**Recommendation Report for Listed Building Consent for Alterations, Extension or Demolition of a
Listed Building**

REF NO: AB/157/25/L

LOCATION: 38 Maltravers Street
Arundel
BN18 9BU

PROPOSAL: Listed building consent for the replacement of 2 No existing external gates.

Drawing Name
Gate 2 Elevations -
Proposed

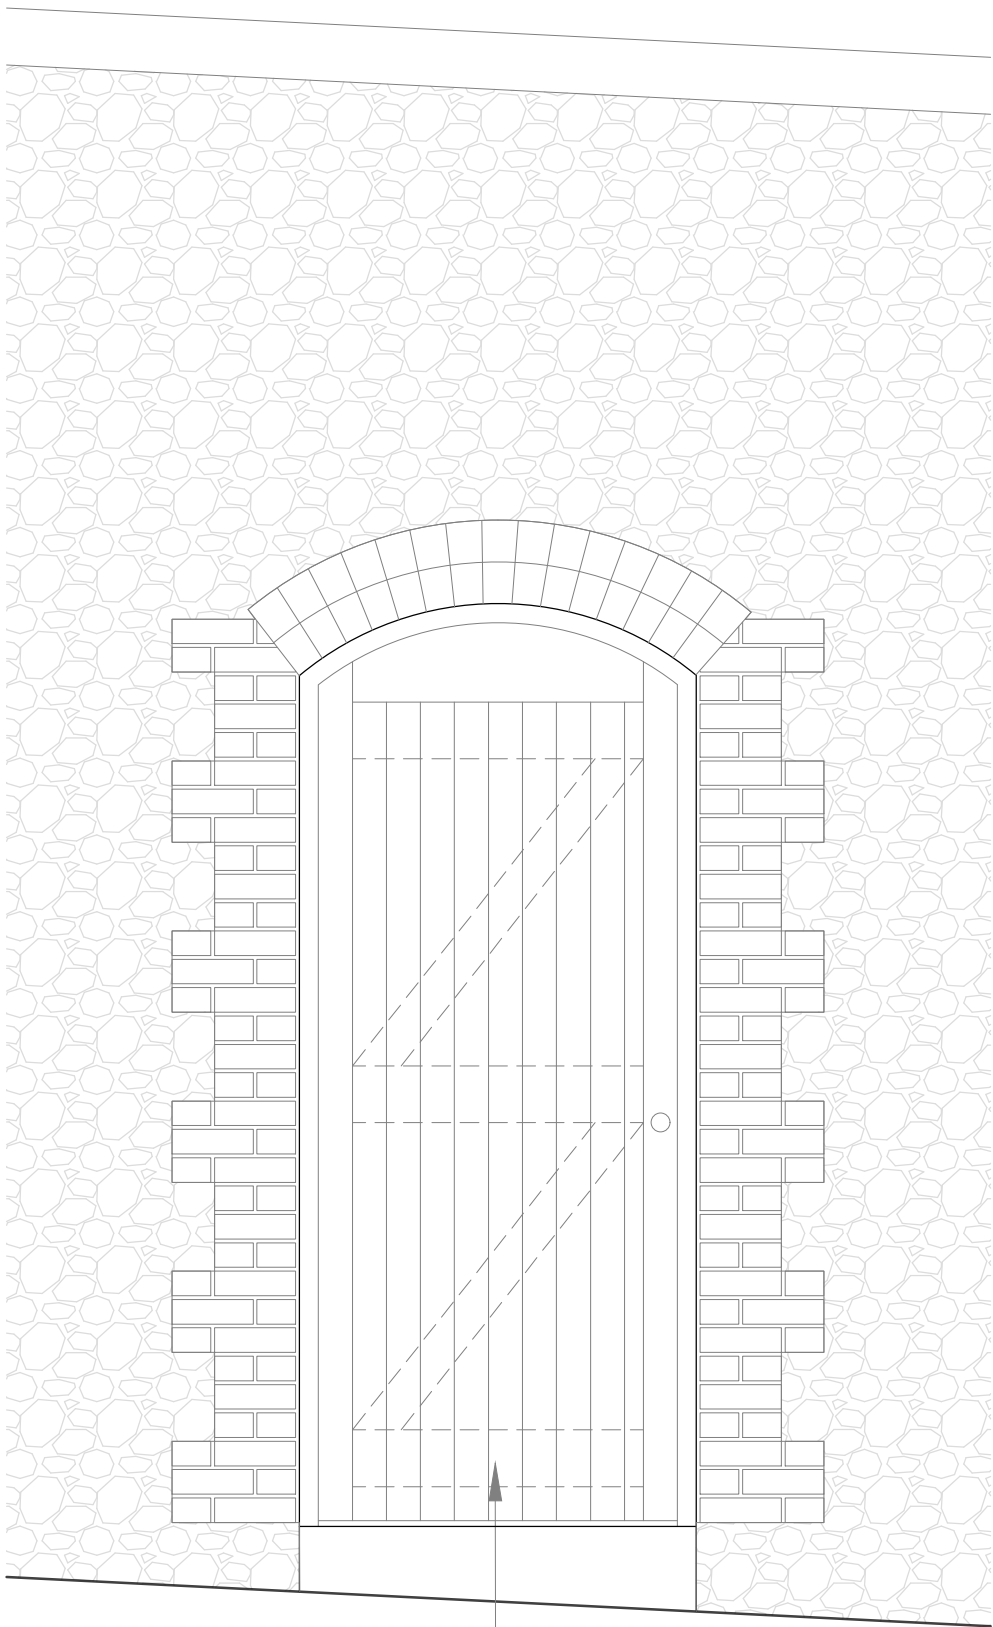
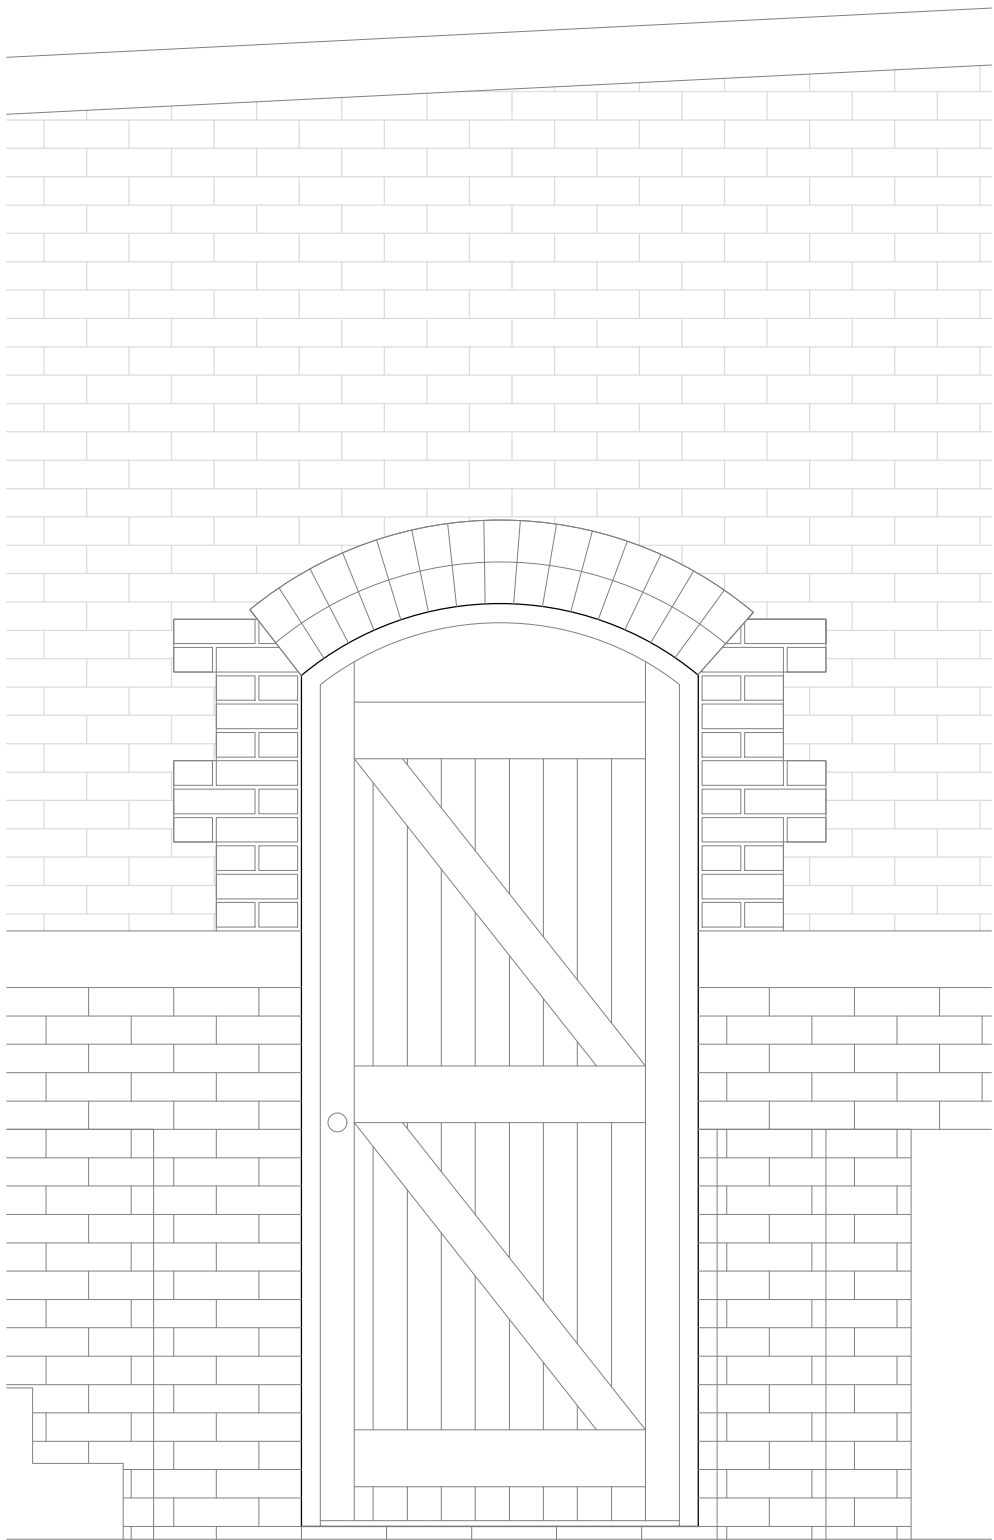
The proposal is for the replacement of two existing external gates. While the justification for their replacement is not fully explained, I am satisfied that the proposed designs would not cause harm. However, although it is stated that the gates will be constructed in air dried oak, it is not specified whether they are to be painted, oiled, or left to weather naturally.

Comments noted. The planning agent has since confirmed that the gates are to be finished with oil.

The replacement gates are appropriately designed and sited. The gates would be constructed in air dried oak and would be oiled finished. Whilst it is acknowledged that the finish would be different when compared to the existing gates, the oiled finish would be appropriate and would not result in harm to the setting or significance of the listed building and the proposals are in accordance with Arun Local Plan policies HER SP1 and HER DM1 and the NPPF.
